Please ask for: Nicola Moore
Email: nicola.moore@arun.gov.uk
Telephone: Ext 37944
Our Ref: BR/31/22/PDH
Your Ref:
Date: 23rd February 2022

Prior Notification for a Permitted Development (Householder)

Development: Notification under extended permitted development rights for a single storey rear extension measuring 4m from beyond the rear wall of the original dwelling house, with maximum height of 3m and eaves height of 2.50m.
Location: 26 Gibson Way Bognor Regis PO21 1AW

Proposed Ground Floor Plan

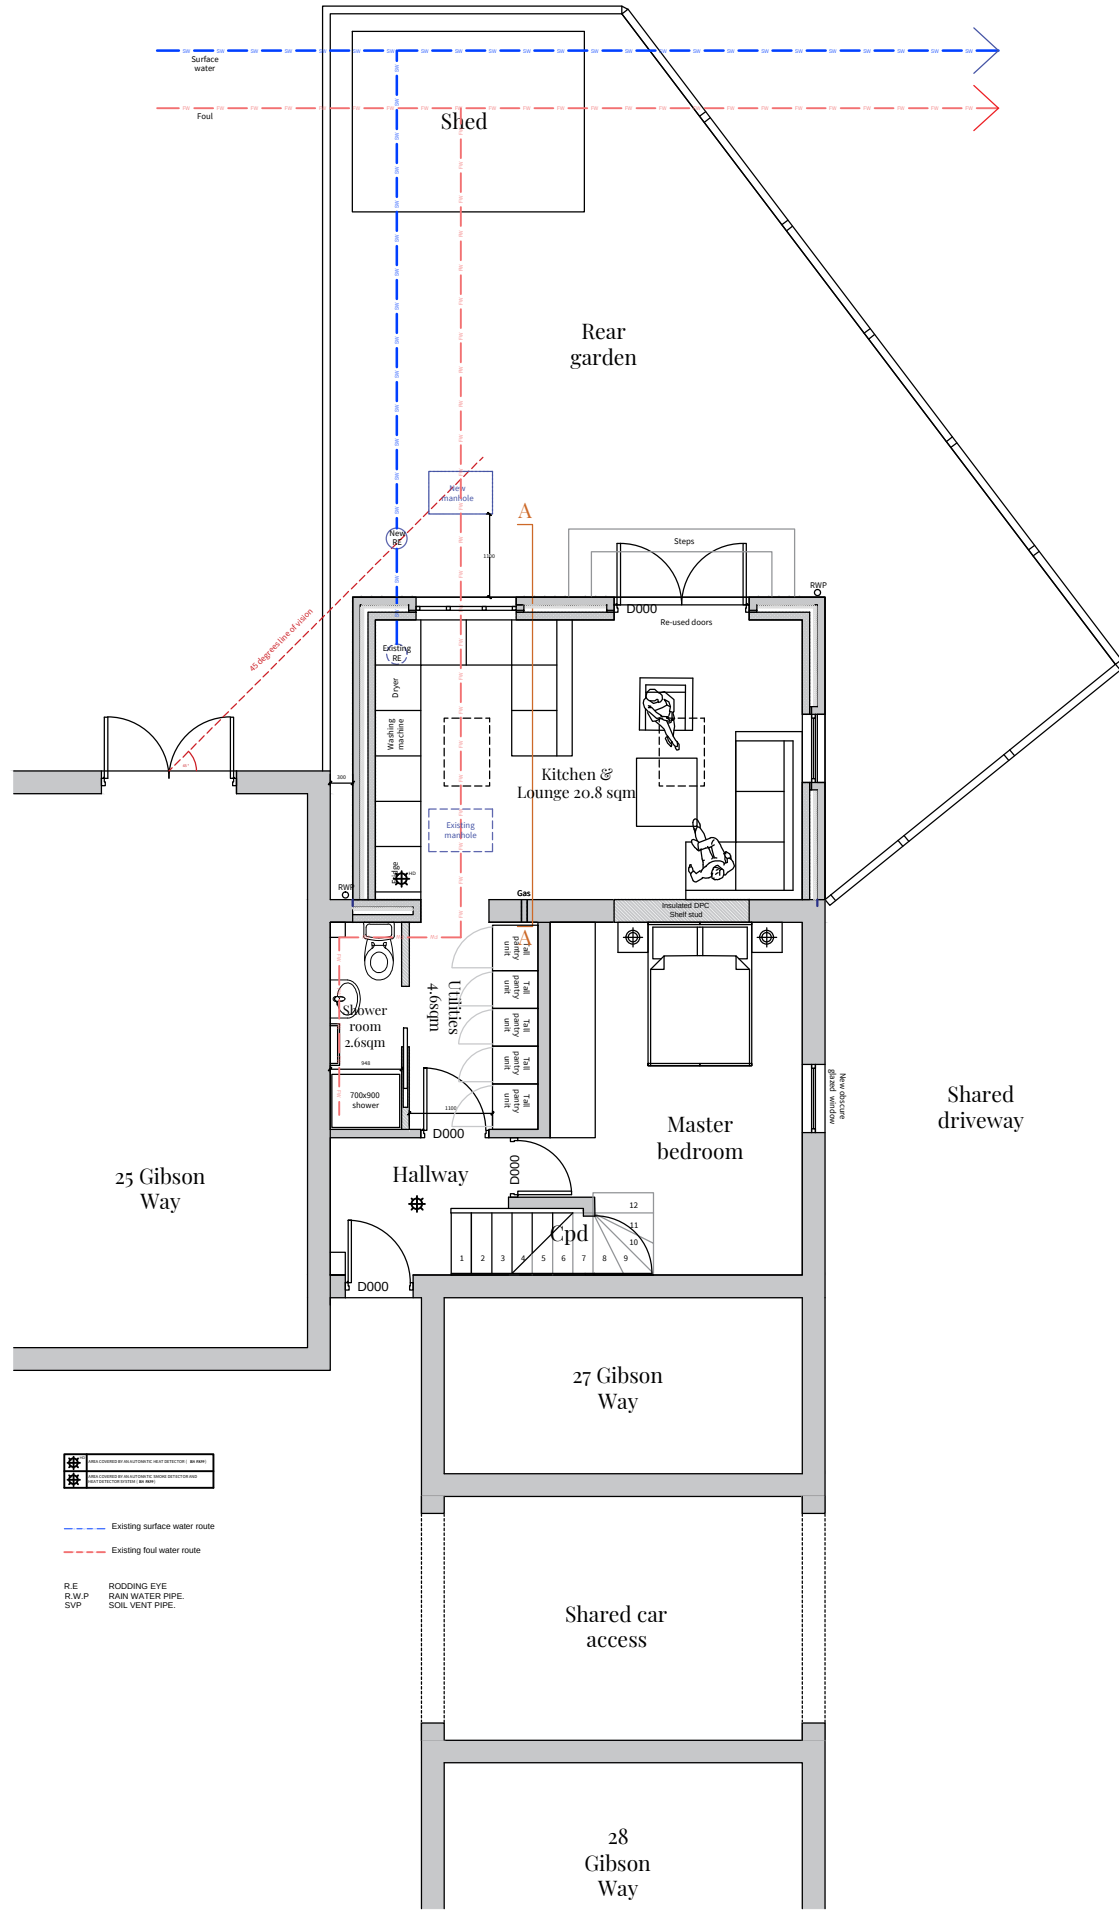
The scale bar on the Proposed Ground Floor plans is 3m, but when measured is 2.70m. Please check the following measurements on the proposed extension:
Door = 1.70m on Proposed Elevation and 1.48m on Floor Plan
Window = 1.27m approx on Proposed Elevations and 1.10m on Floor Plan
Side windows = 0.8m on Proposed Elevation and 0.7 on Floor Plan.
Please amend accordingly and resubmit.
